3 October, 2023

From: Rosemary Baisch Dunkle, Director
Fowler Creek Ranch / FC RANCH LLC
2040 Fowler Creek Road
Cle Elum, WA 98922

To: Planning Commission of Kittitas County
c/o Jamey.Ayling@co.kittitas.wa.us

RE: Conditional Use Permit Application CU 23-00003

EXHIBIT 16 - SITE PLAN - FOWLER CREEK GUEST RANCH

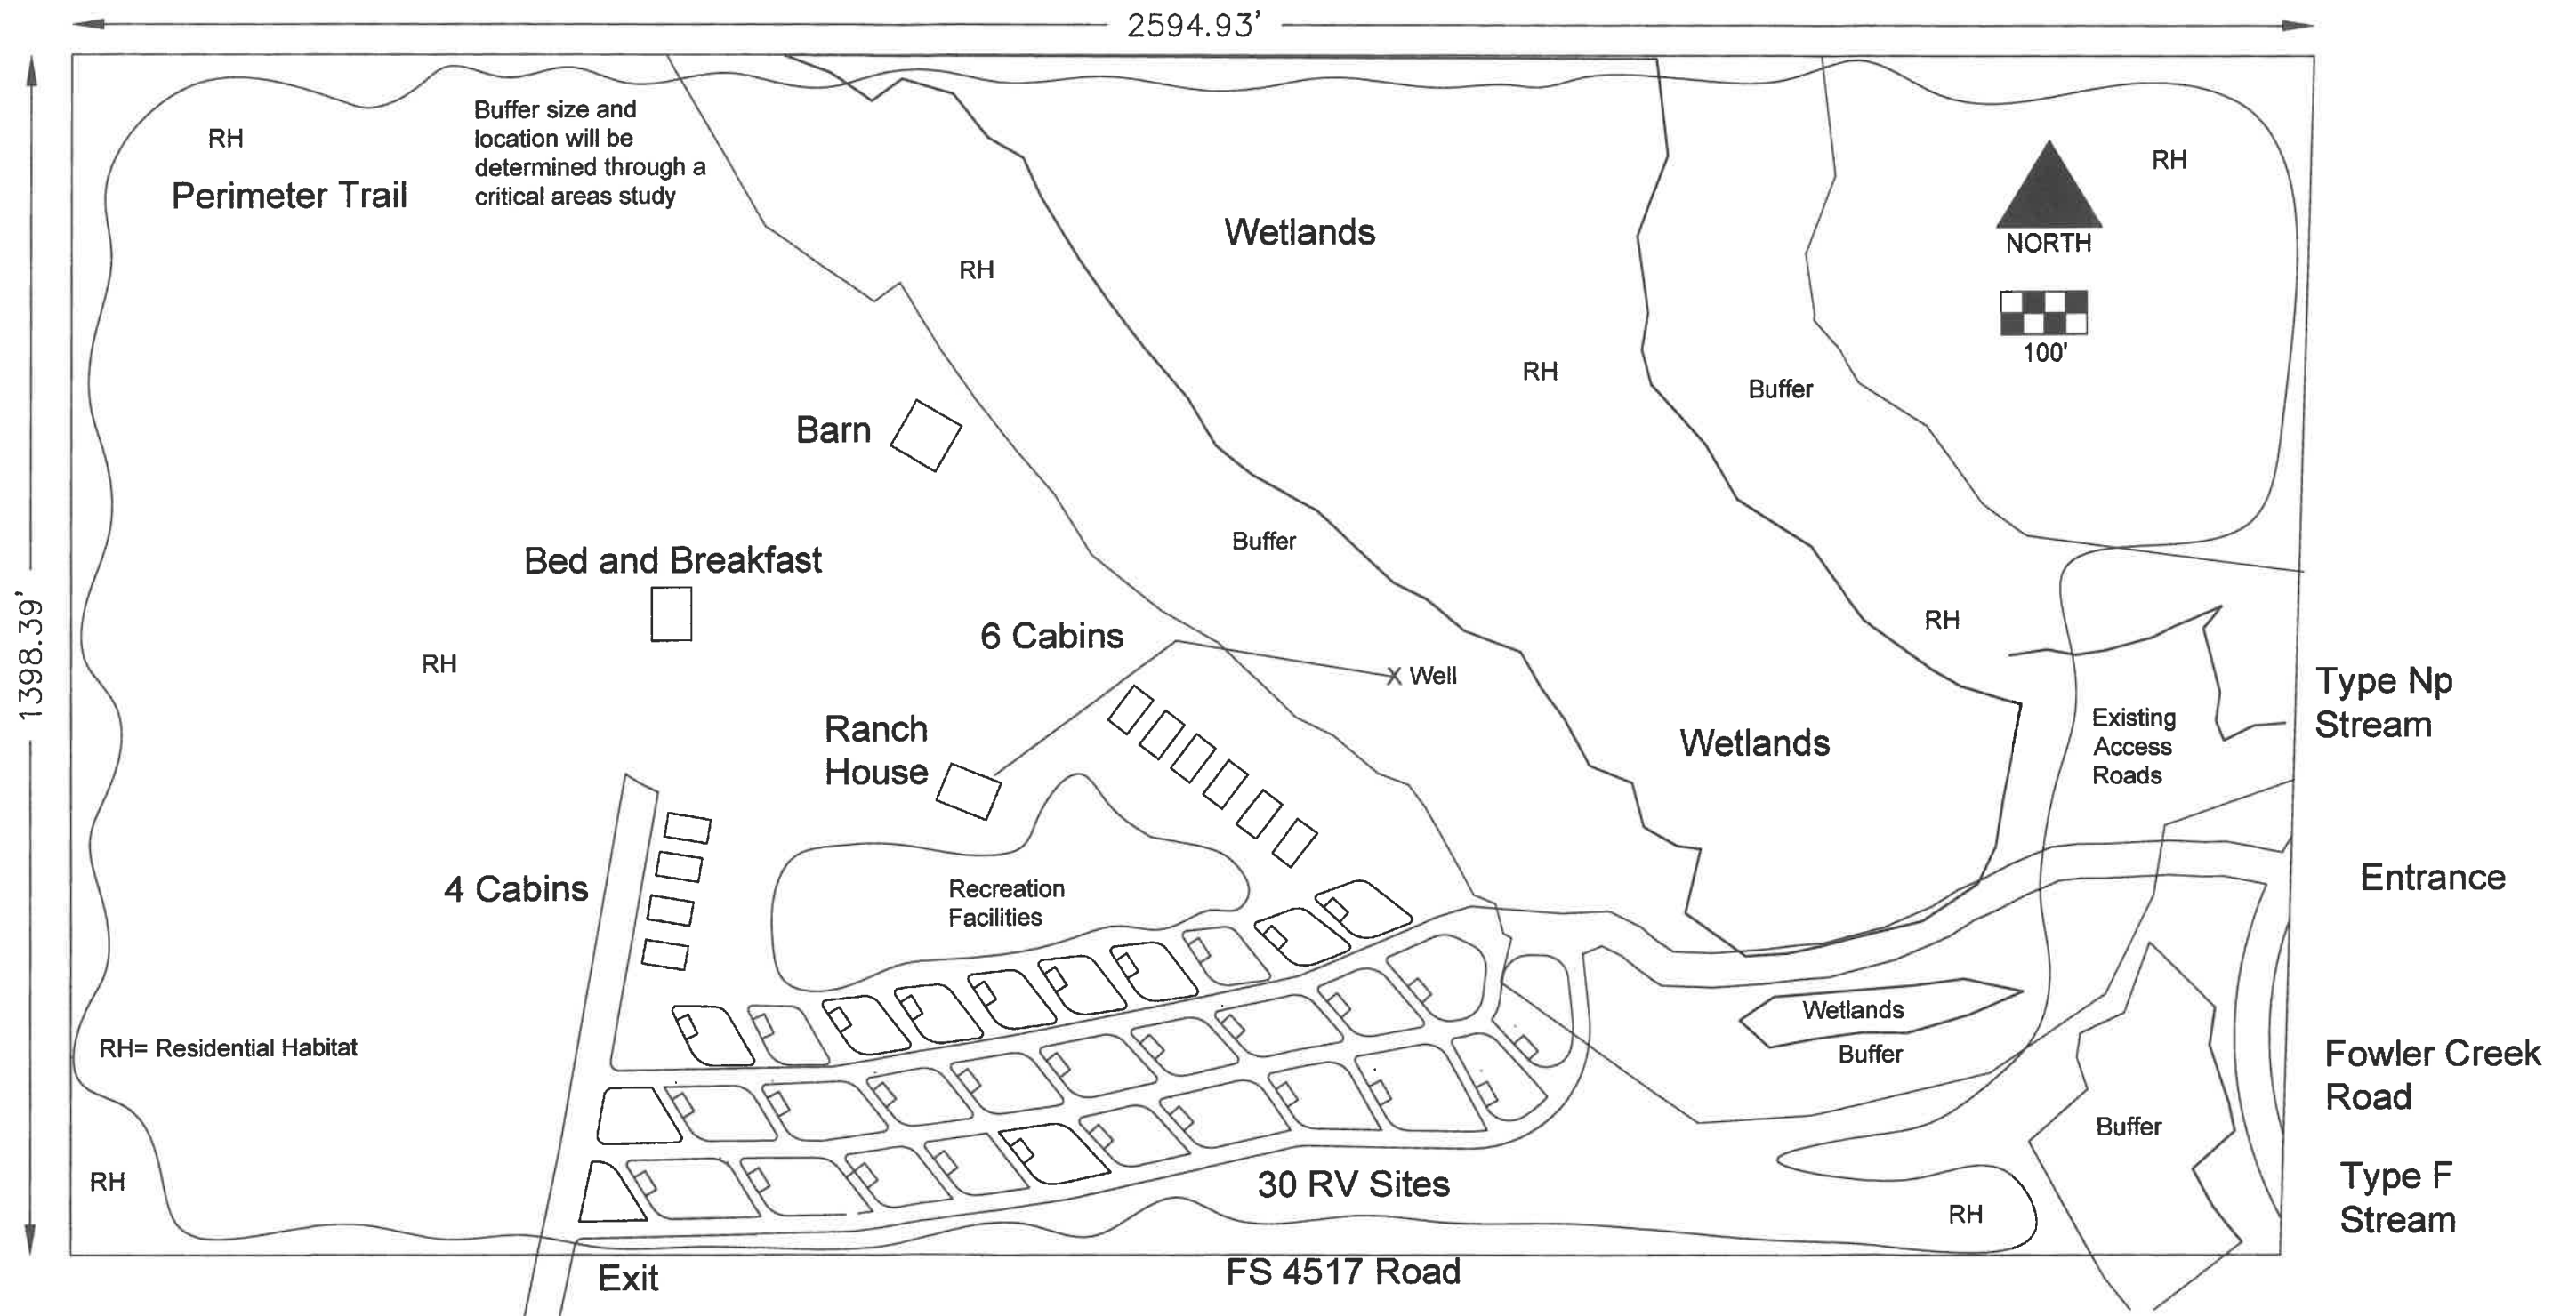
The current plan tightly clusters the 30 RV camping sites on the property's southern boundary. A key reason that people choose to recreate in an RV versus tent camping is that they like to take their creature comforts with them – heat, TVs, lights, kitchen appliances. These comforts require external power generation, and generators are loud. No consideration has been made in the proposal to quantify and consider the impact of the 30 clustered RV generators to the peace, air quality and character of the nearby forest and neighboring properties.

Furthermore, the light plan does not consider the light emanating from the 30 RVs parked along the Southern border of the property. These lights will travel far into the forest, disrupting nighttime habitat of birds of prey and other nocturnal hunters, especially during the fall and winter months when deciduous trees lose their leaves.

Furthermore, RVs produce greater road discharge and pollution than standard vehicles, and always present a risk of the accidental discharge of fuel and/or raw sewage. The proximity of this vast parking area is very close to Fowler Creek. This Proposal does not adequately discuss safeguarding the quality of the water in Fowler Creek.

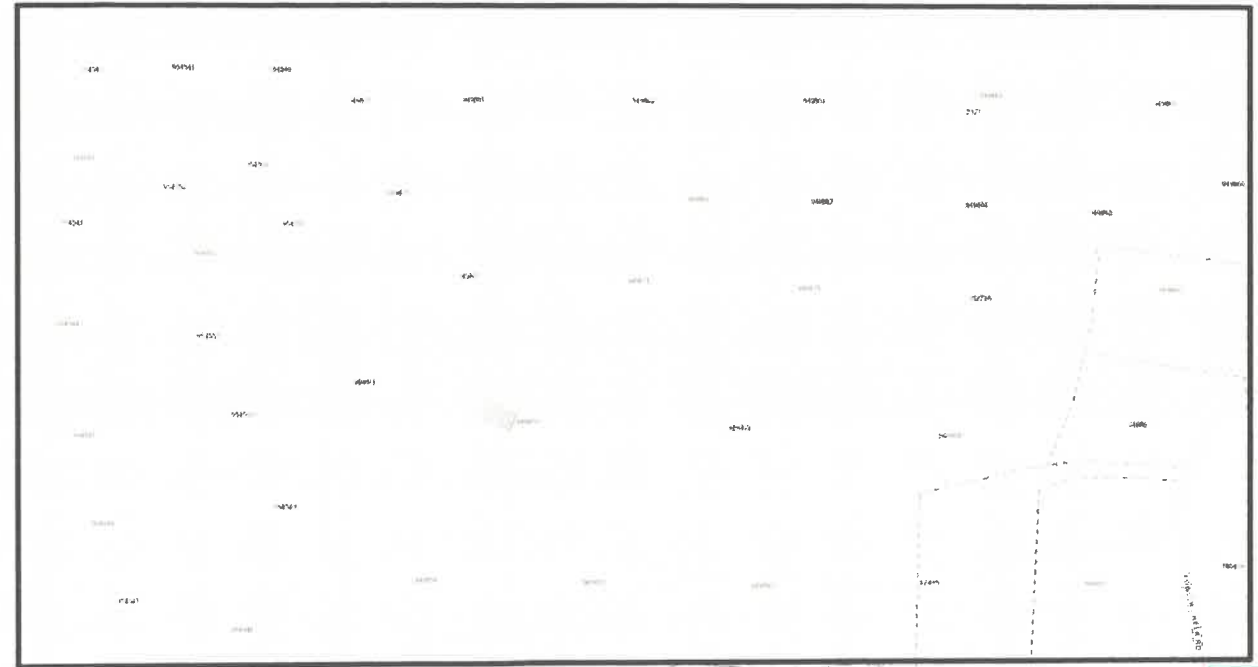
The applicant submitted a map noting the properties generally surrounding the proposed development project. My property, located South and Southeast of the project (parcels 775434, 952255, 952256, 952257 and 952258, etc.), is closer than a number of properties considered (555434, 789134, 875934, 885934), however the impact to mine was not considered. I would argue that the impact of noise in the evening (after 9:00 p.m.) and lights after dark will have a dramatic impact on the character of, and peace I find on, my land. Furthermore, the use by guest ranch visitors of the trails under the power lines and along the Western and Southern boundaries to my property (see item 5 above) will require me to more extensively demarcate the boundaries at considerable expense. For these reasons I would like the impact to my land be considered along with the ability to comment.
